Our ref no: DOC19/740889
Your ref no: SSD 10339

RE: Notice of Exhibition – SSD Additional to approved Acute Services Building for Health Research Use (SSD 10339 at Prince of Wales Hospital Campus (Part Lots 4-11 DP 13995 and Part Lot 1 DP 870720, Hospital Road, Randwick (Randwick LGA))

Figure 7-9 Map of archaeological potential within the SSDA boundary (Source: Casey and Lowe, 2019).

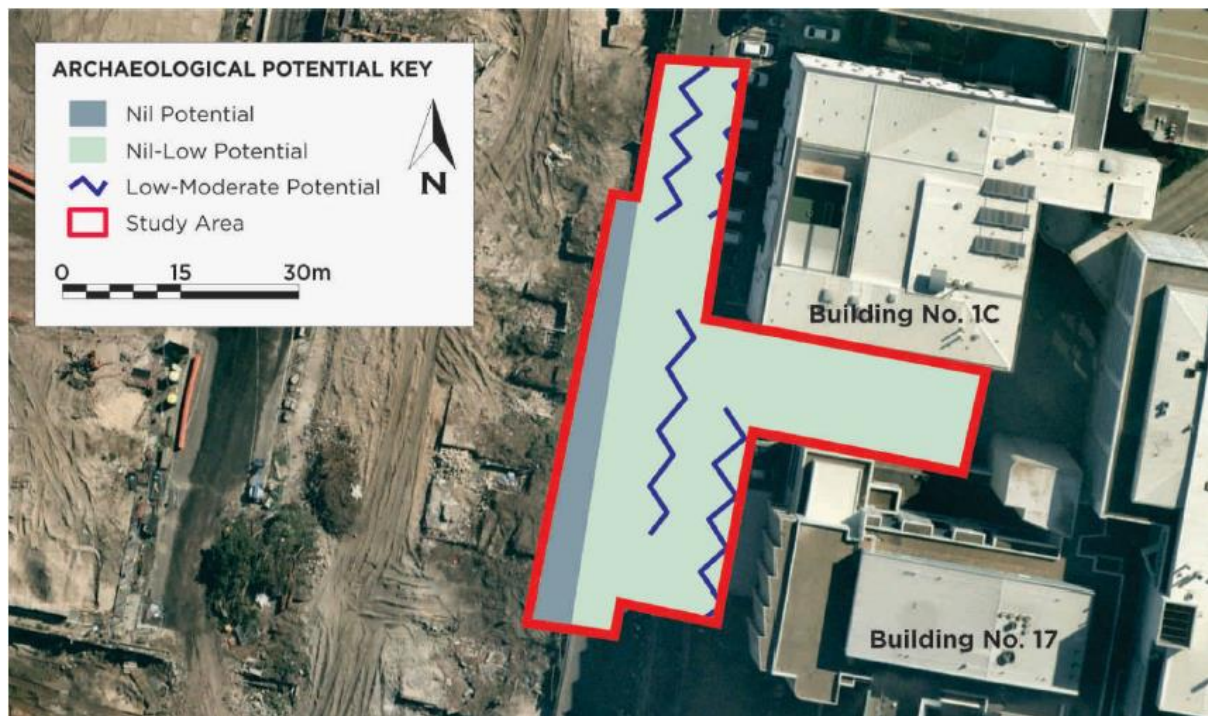
The EIS has considered the previous historical occupation which is documented for the study area and its likelihood to retain archaeological relics requiring management. The site is close to the former Randwick Destitute Children's Asylum, Cemetery and other associated buildings. However, none of these structures or associated out-buildings are known to exist within the study area. The Assessment prepared by Casey and Lowe has identified the presence of a series of WWII air raid slit trenches were established in the site. It is argued that these may contain backfilled material which could have research potential for artefacts linked to the Asylum (1857), associated Receiving House (1878) and Military Hospital (1912/1918) phases.

There is no evidence to explain how backfilled material from the earlier phases would be likely to be present in the slit trenches which would have been backfilled following the end of WWII. There is also no link in the proposed research design to explain how the archaeological investigation of the slit trenches would provide evidence of this nature and how this would provide new information not currently available from other (historical documentary and oral) sources.

The Archaeological Assessment prepared by Casey and Lowe has not demonstrated there are archaeological 'relics' with research potential within the meaning of the *Heritage Act 1977* and the Heritage Council's current guidelines. An archaeological program is not recommended for this SSDA and no conditions of consent are included with this letter. The project can be adequately managed through an unexpected finds procedure within the remit of a Construction Environmental Management Plan (CEMP).
